From: Richard Dollamore [REDACTED]
Sent: 24 January 2020 14:08
To: Simon Davis <Simon.Davis@arun.gov.uk>
Cc: 'Gareth Giles' [REDACTED]
Subject: RE: Inglenook P/58/19/PL
Importance: High

Subject: RE: Inglenook P/58/19/PL

Refuse Vehicle
Swept Path Analysis

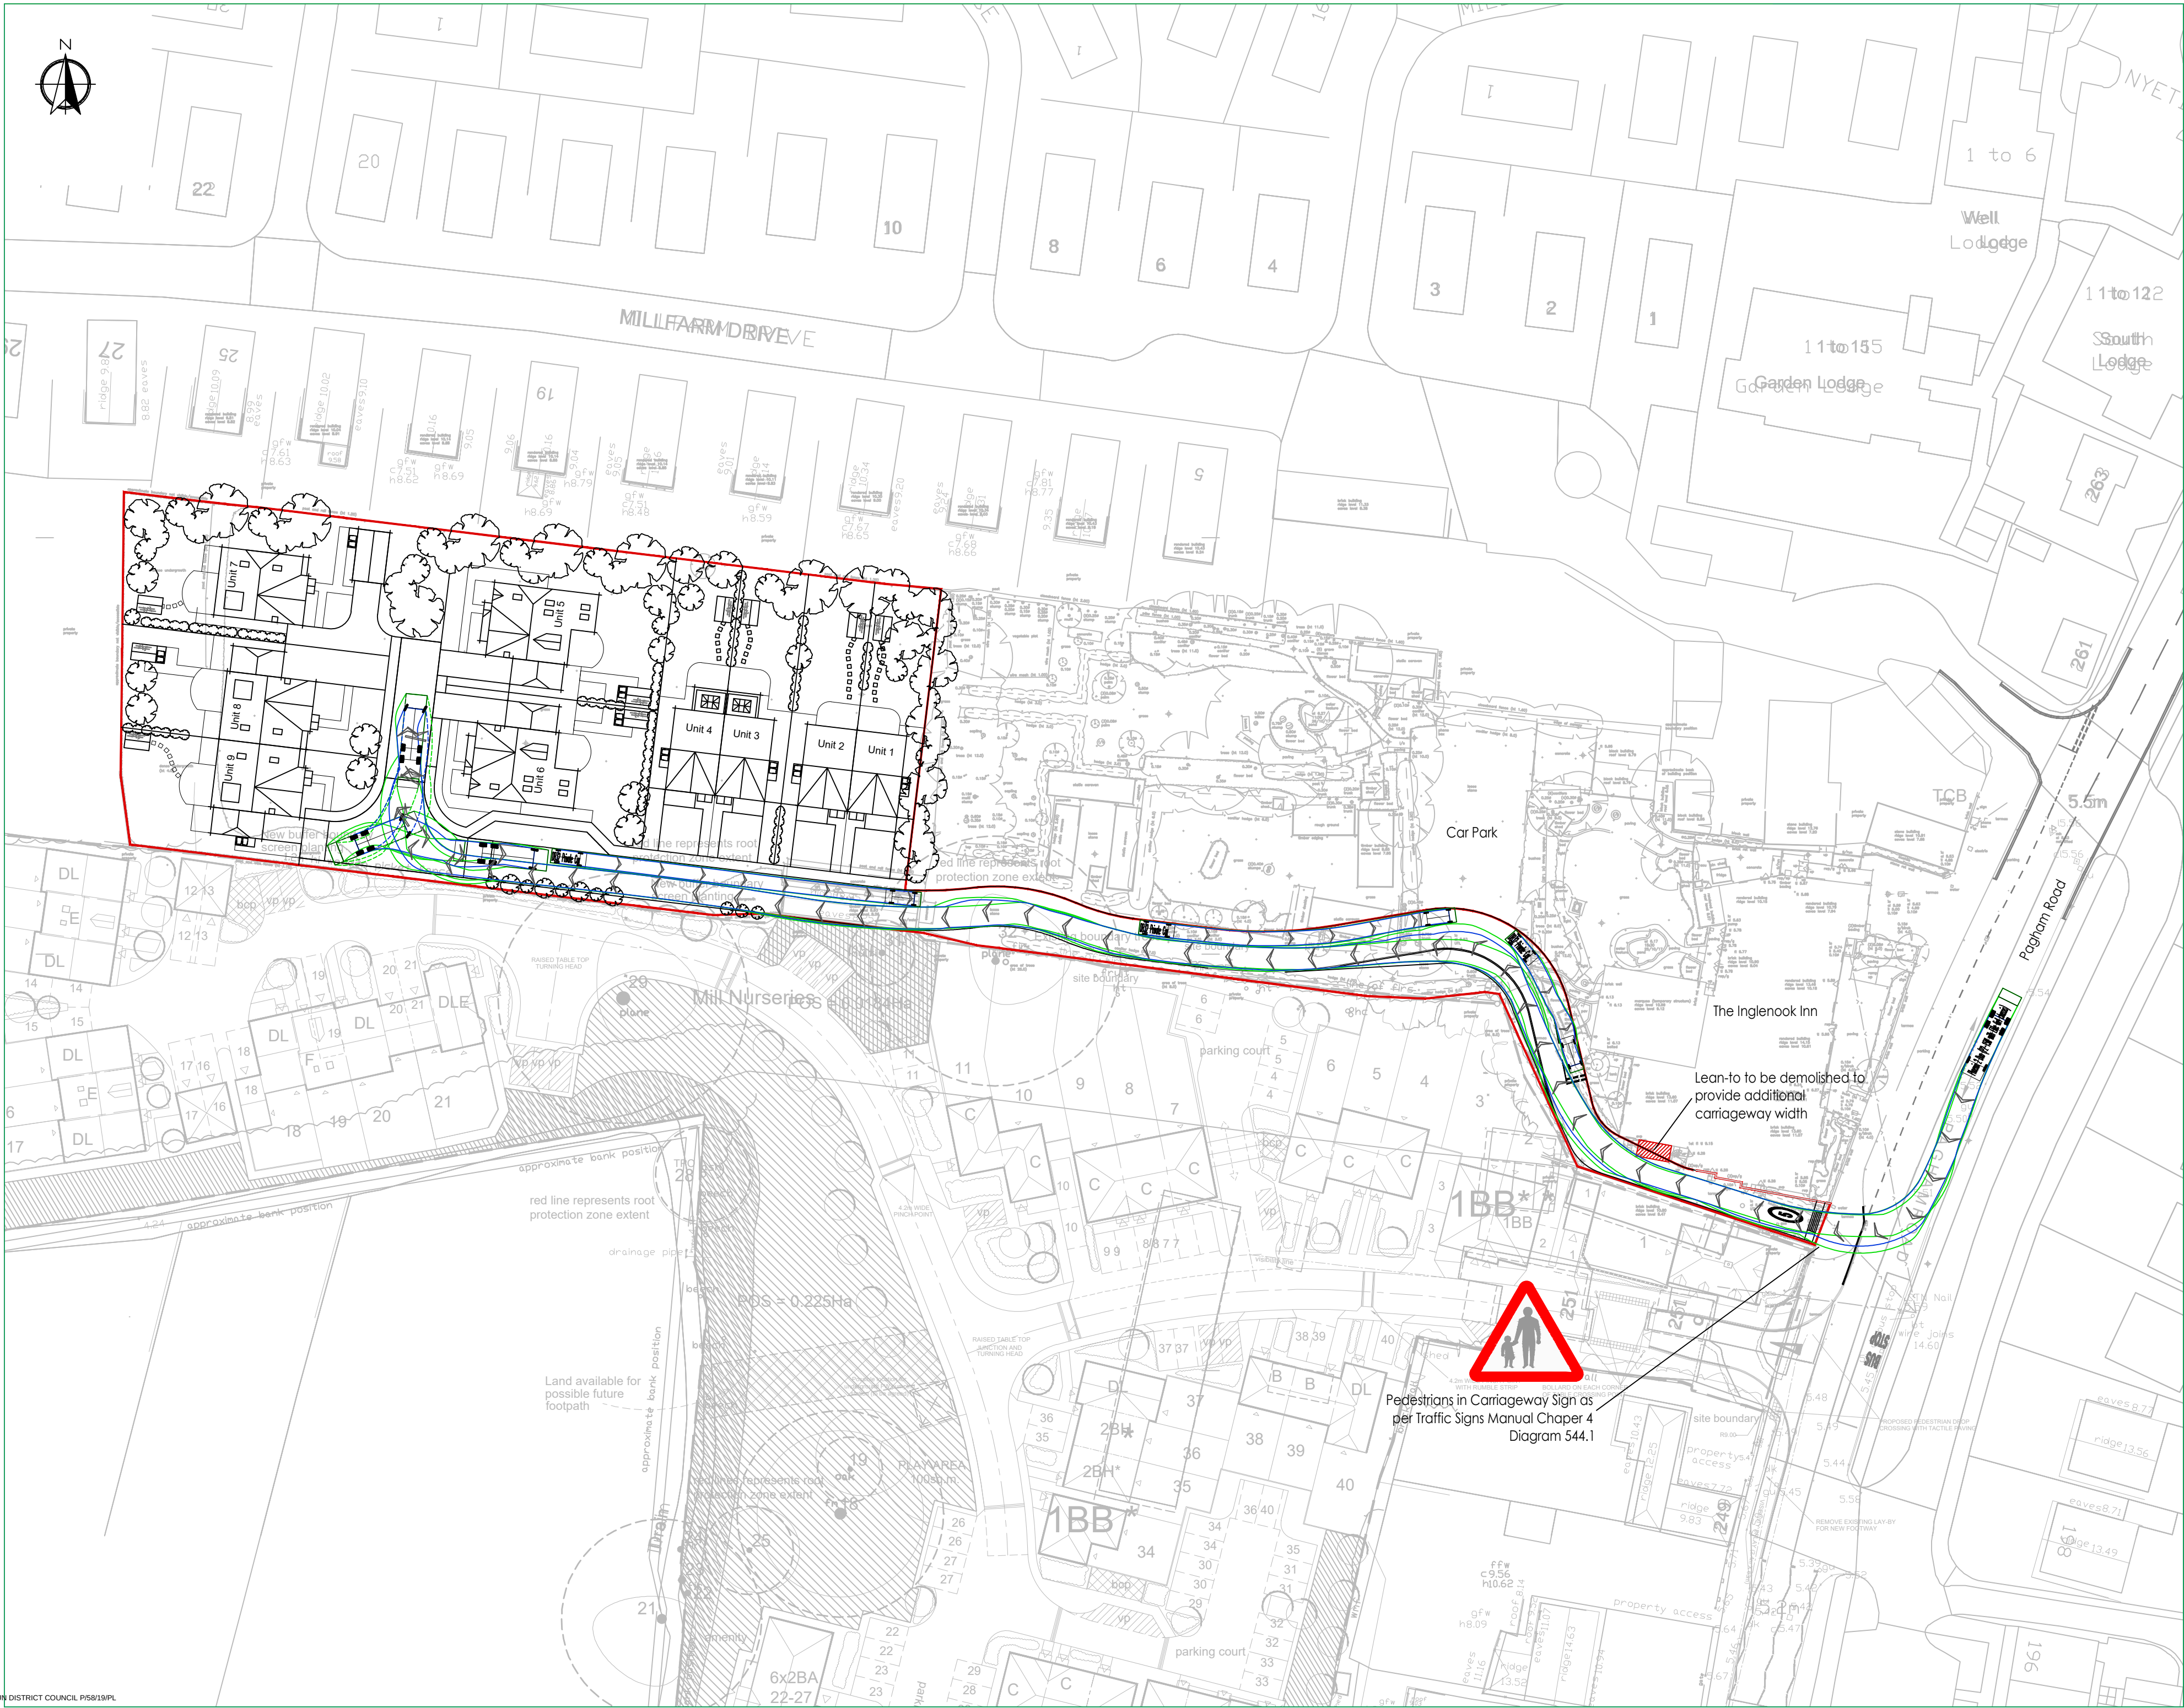
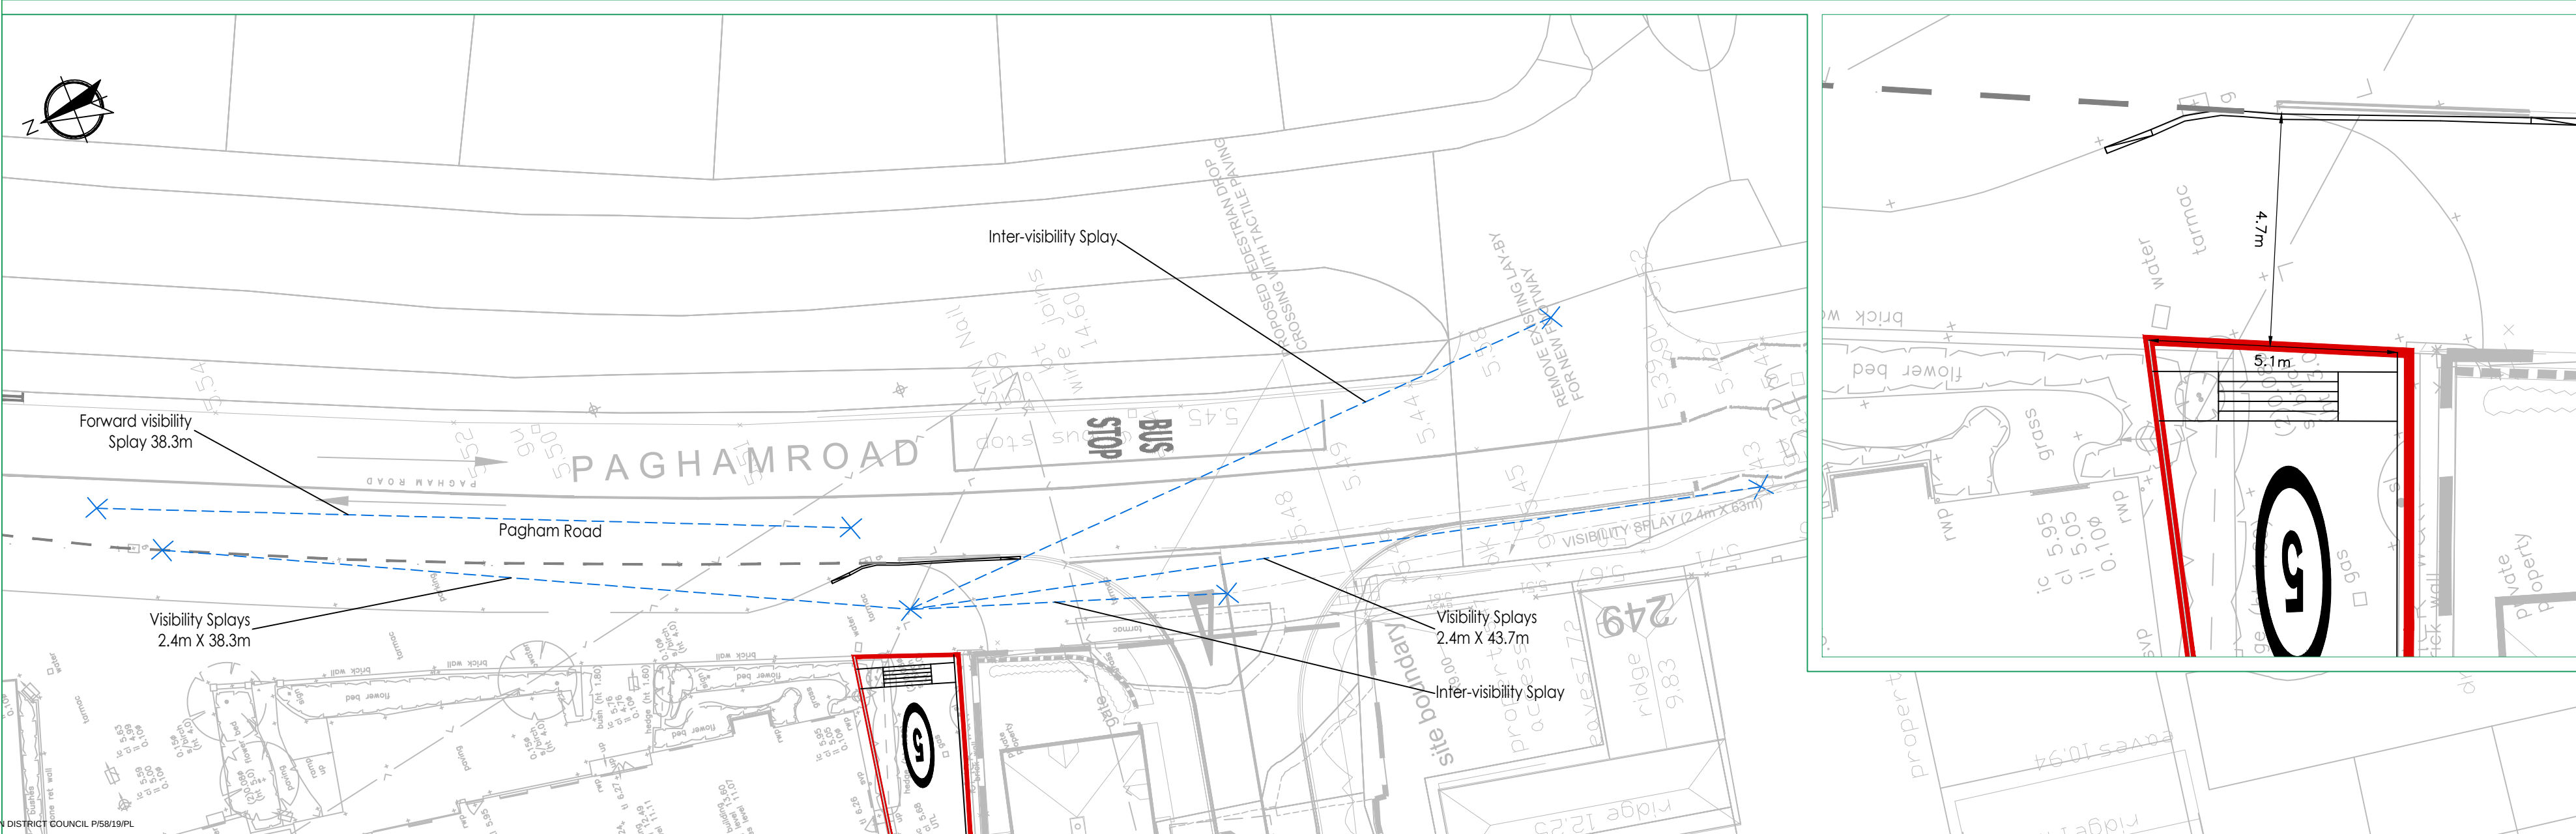
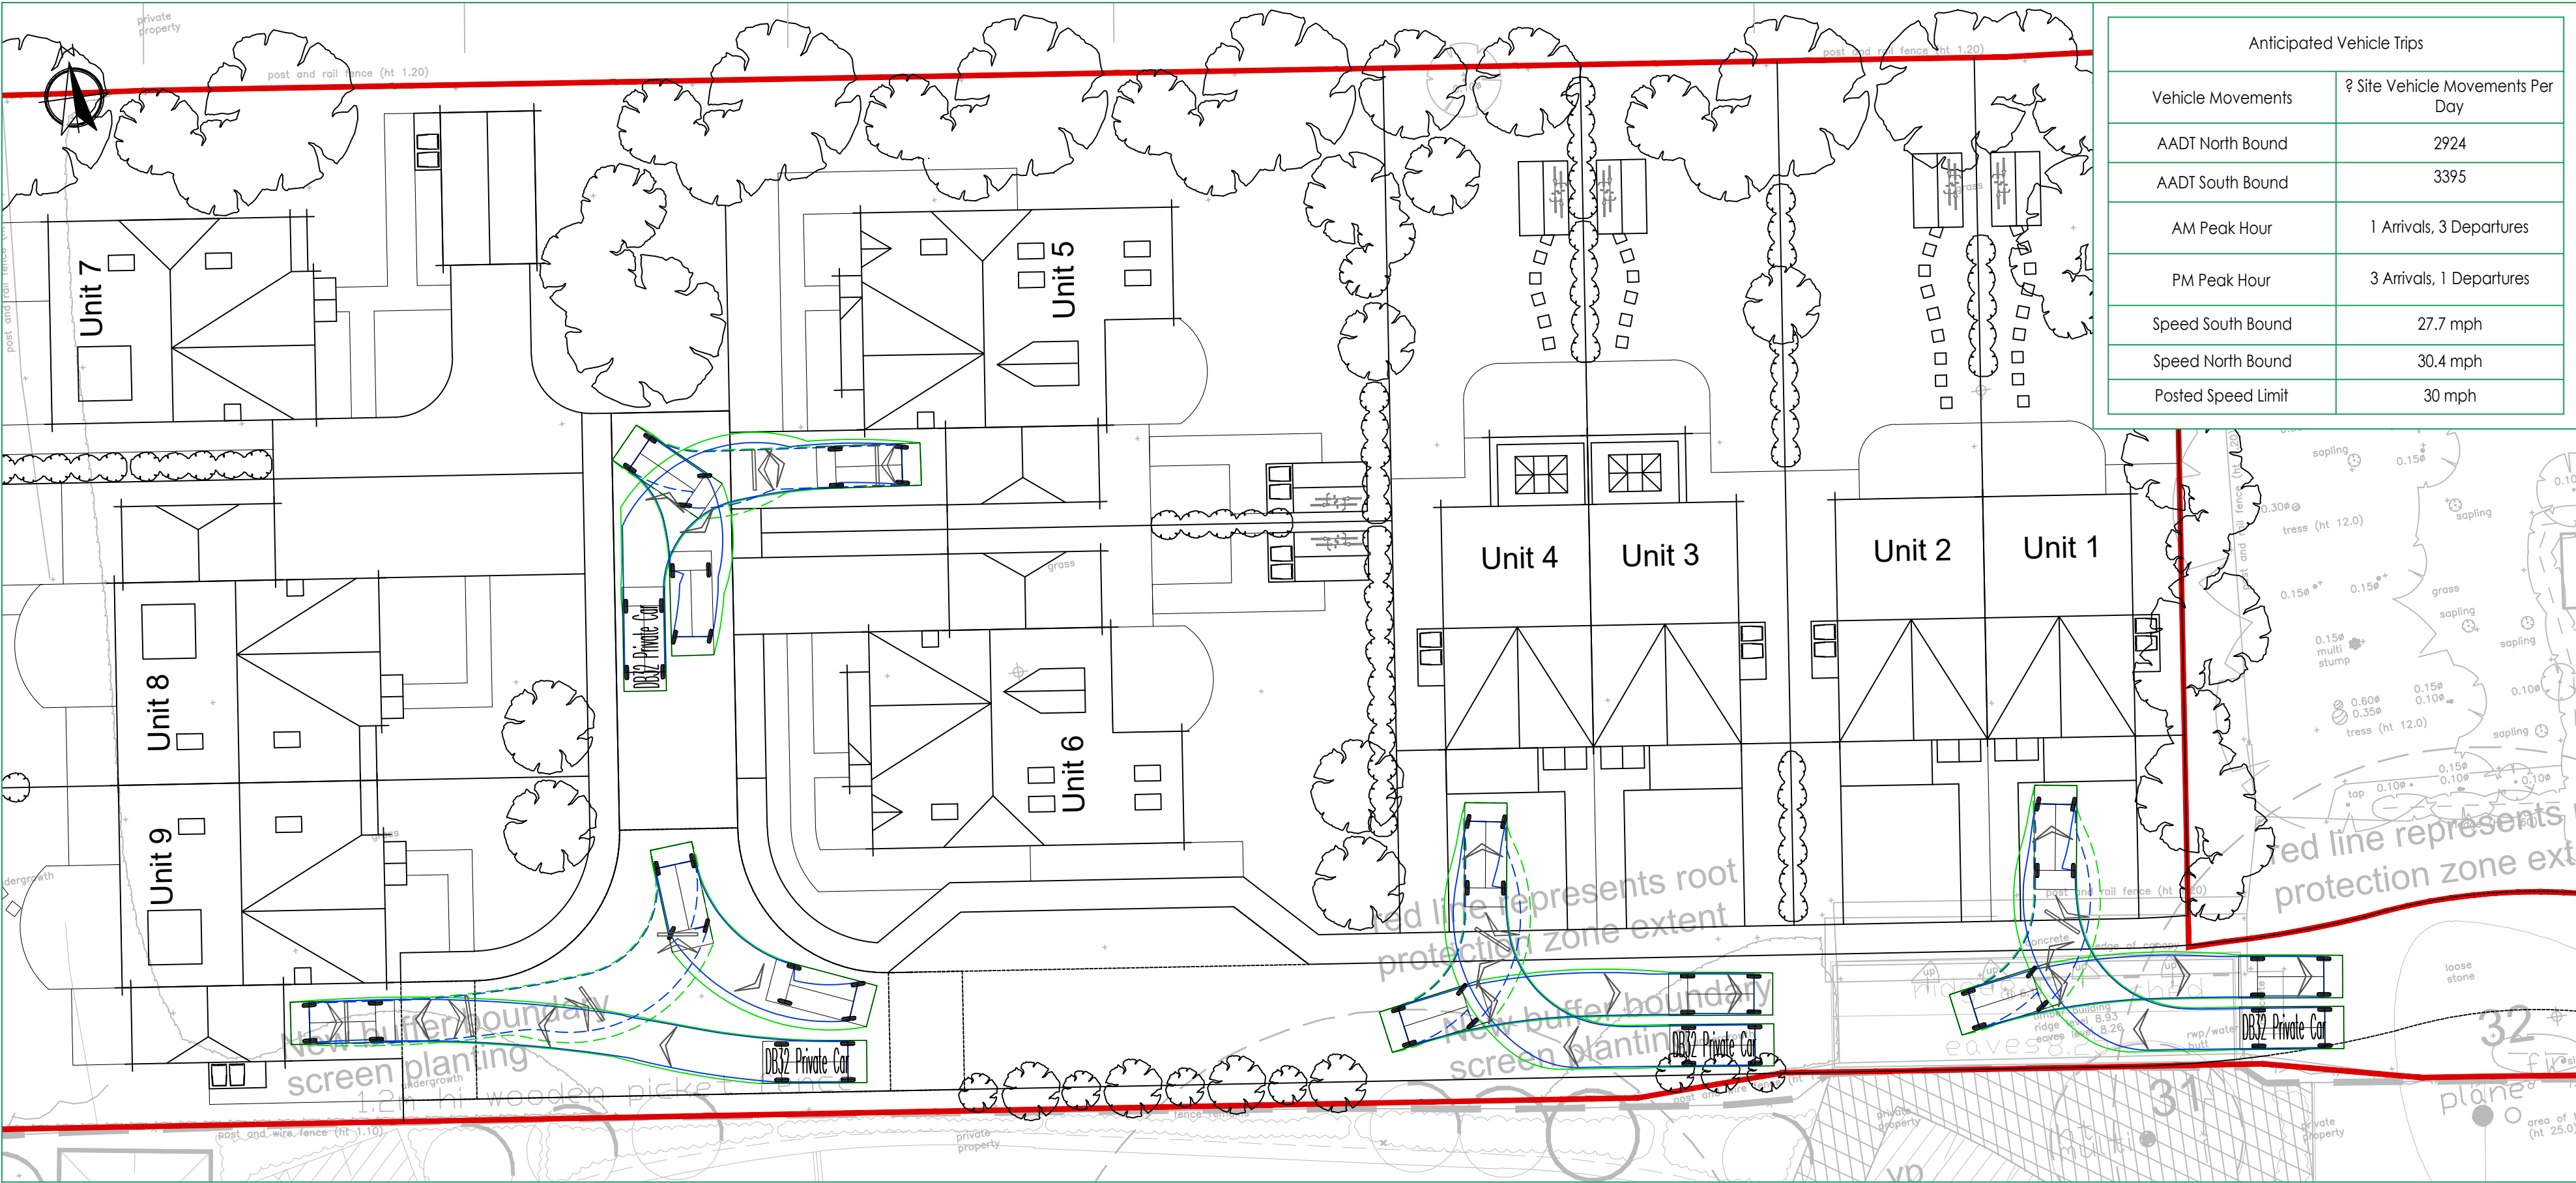
- *The swept path analysis doesn't take account of any parked vehicles on Pagham Road. There are currently no restrictions and a refuse vehicle would not be able to make a turn with the present arrangements without parking restrictions reducing the existing availability for residents and visitors on-street –*
The swept path analysis submitted with the application at drawing 2017/3763/003 Rev B demonstrates that refuse vehicles would be able to access and egress the site without issue. The double yellow line parking restrictions and presence of the bus stop to the south of the site will ensure that any refuse vehicle manoeuvre to / from the south would be unrestricted. In the event that a vehicle is parked on the eastern side of Pagham Road on the section to the north of the access, a refuse vehicle would still be able to turn in / out of the site towards the north given that the access would be widened as part of the proposals.
